Helios EN010140

Date 18/02/2025

May I respectfully ask for a Site Wide Meeting, from the Black Dog Public House, which is surrounded by a **SUBSTANCIAL amount of Housing**. To discuss the following.

Environmental Statement Figure 11.4: Noise Contour Map Daytime

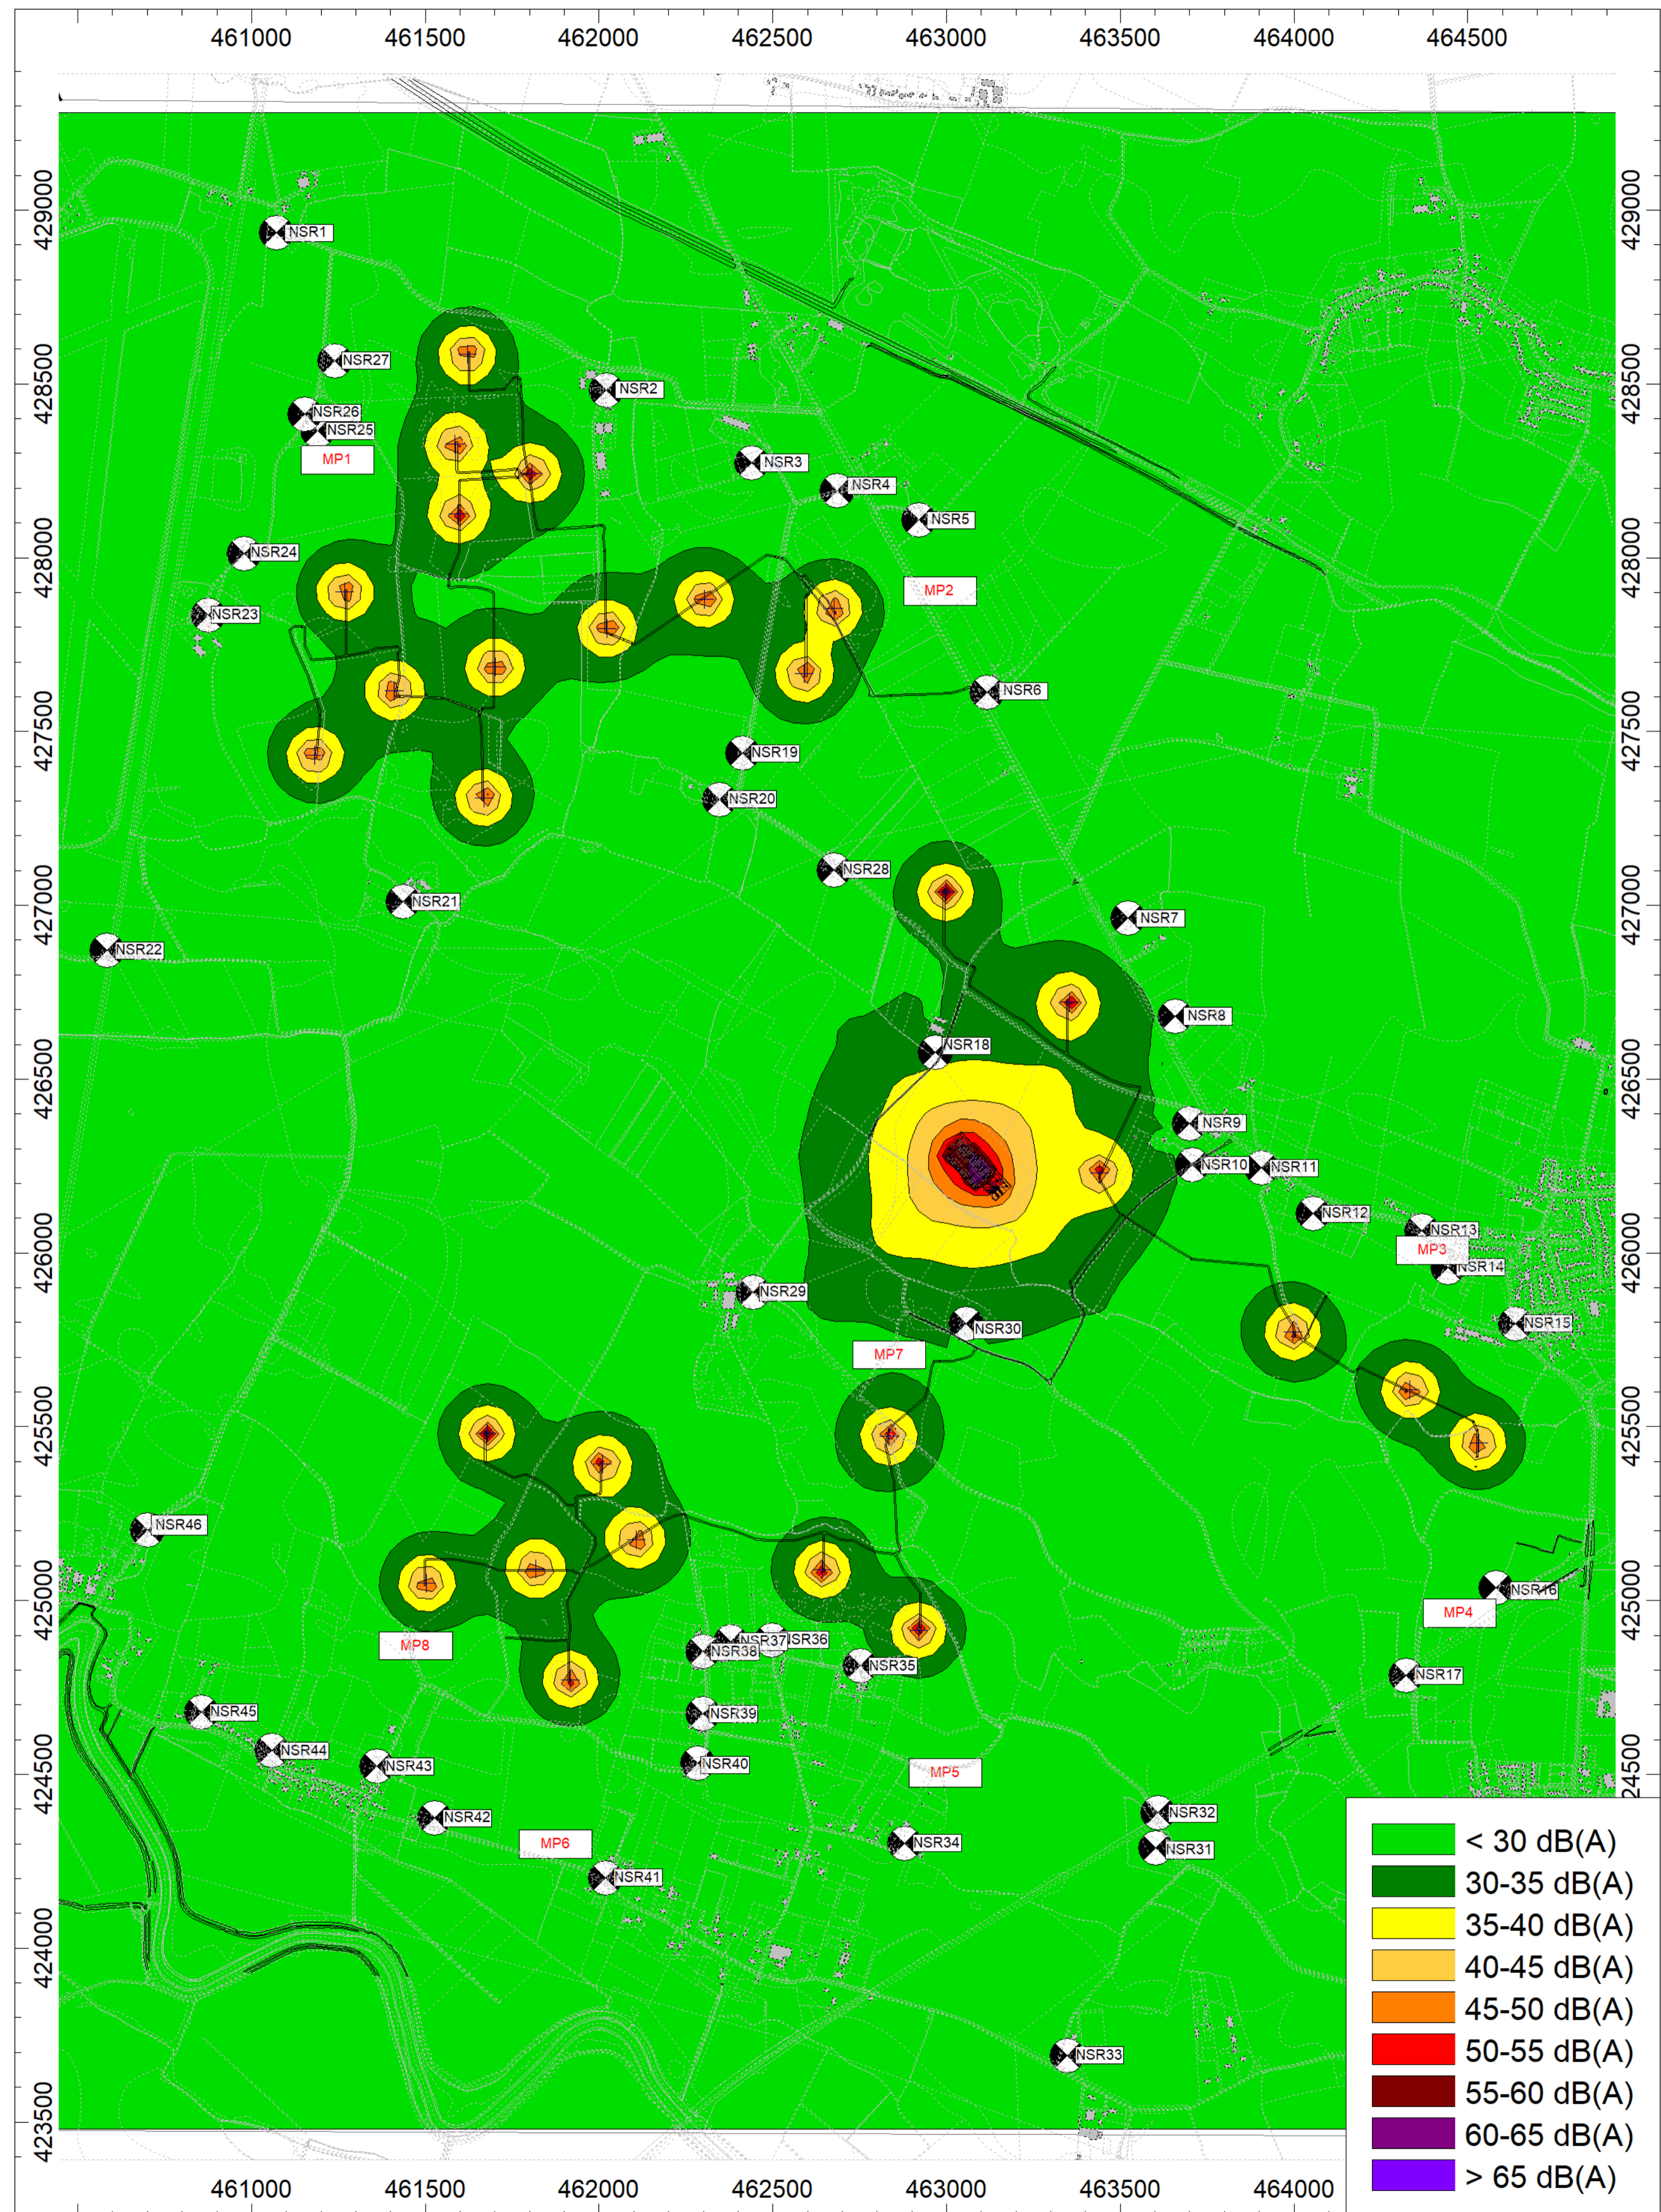
On the poorly detailed Map **Fig 11.4 – Noise Contour Map Daytime**, (my ID Map 7). I would like some independent assurance, that as if by some miracle, we are in the < 30 dB zone.

Environmental statement Figure 11.4 (The map I have supplied number 7), has a symbol Z? which I have added. Whatever it/they are. They have the capability of emitting 45-50 dB of noise. The Z? in question is **ALMOST AT THE BOTTOM OF MY GARDEN**. Due to the poorly detailed map, I could not get a position to measure approx. how close it is

## **Environmental Statement Figure 3.7: BESS Battery Container Elevations**

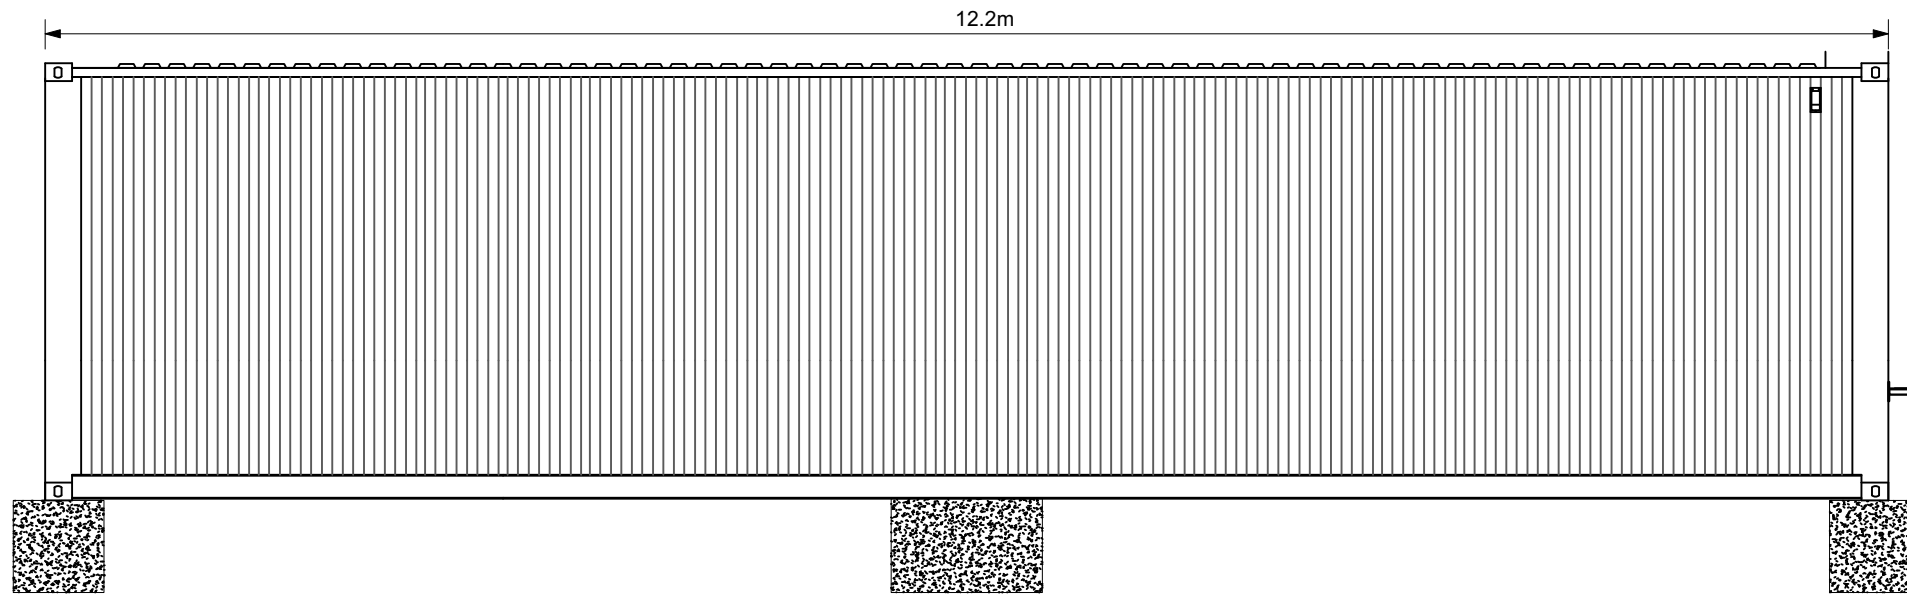
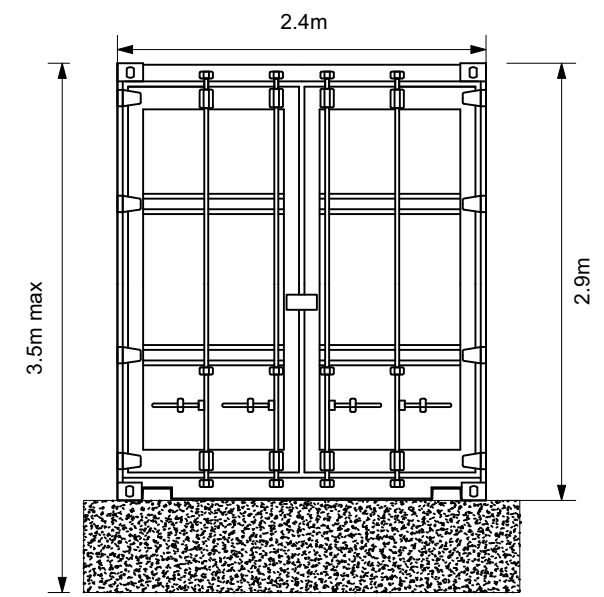
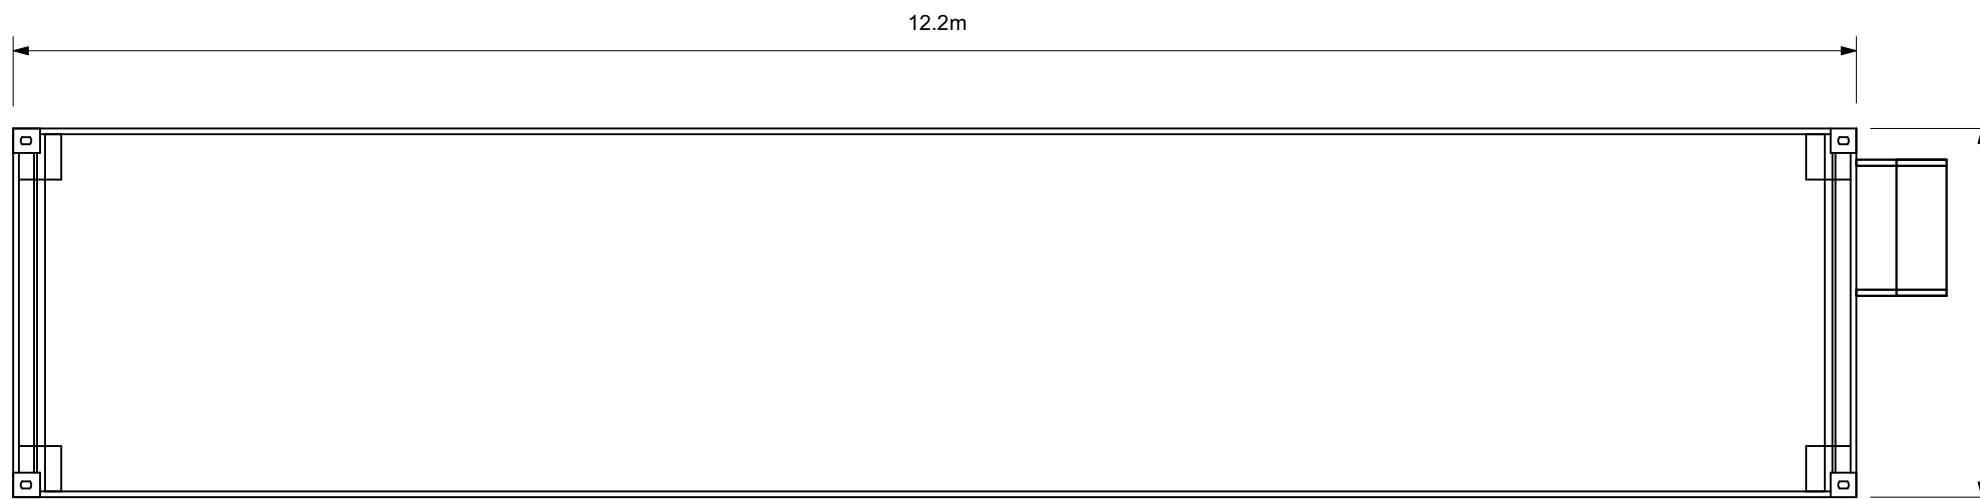
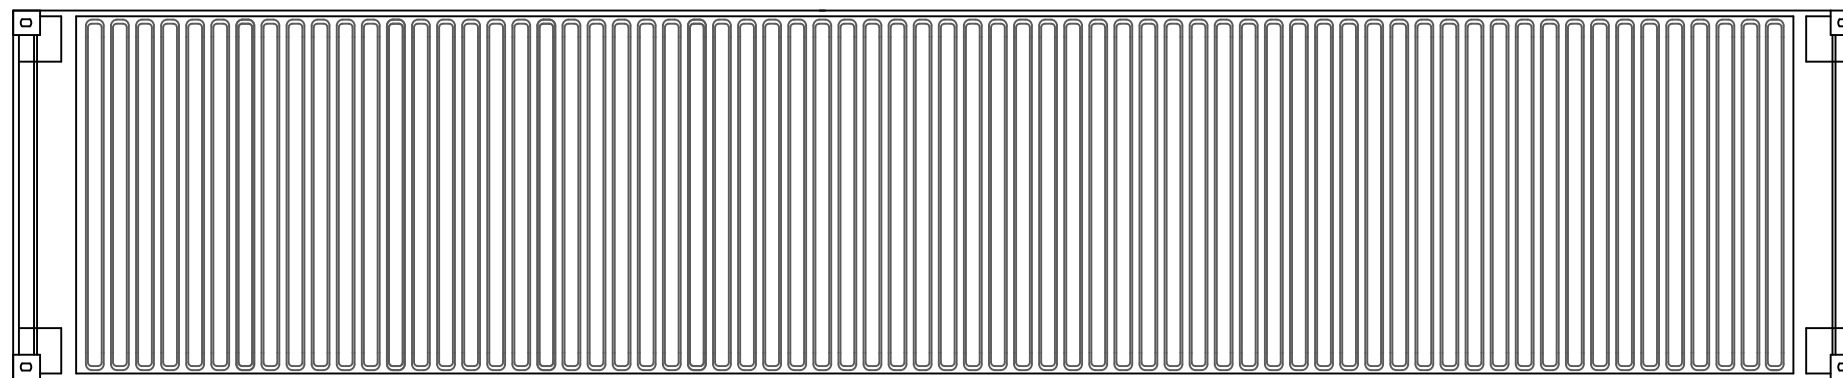
3.4.22 Battery containers of up to 12.2m in length x 2.4m x 3.5 in height.

1. It does not say how many?

- **Battery containers** of up to 12.2m in length x 2.4m in width x 3.5m in height, including concrete supports 600mm in height (refer to **Figure 3.7 BESS Battery Container Elevations [EN010140/APP/6.2.3.7]**); **HOW MANY?**
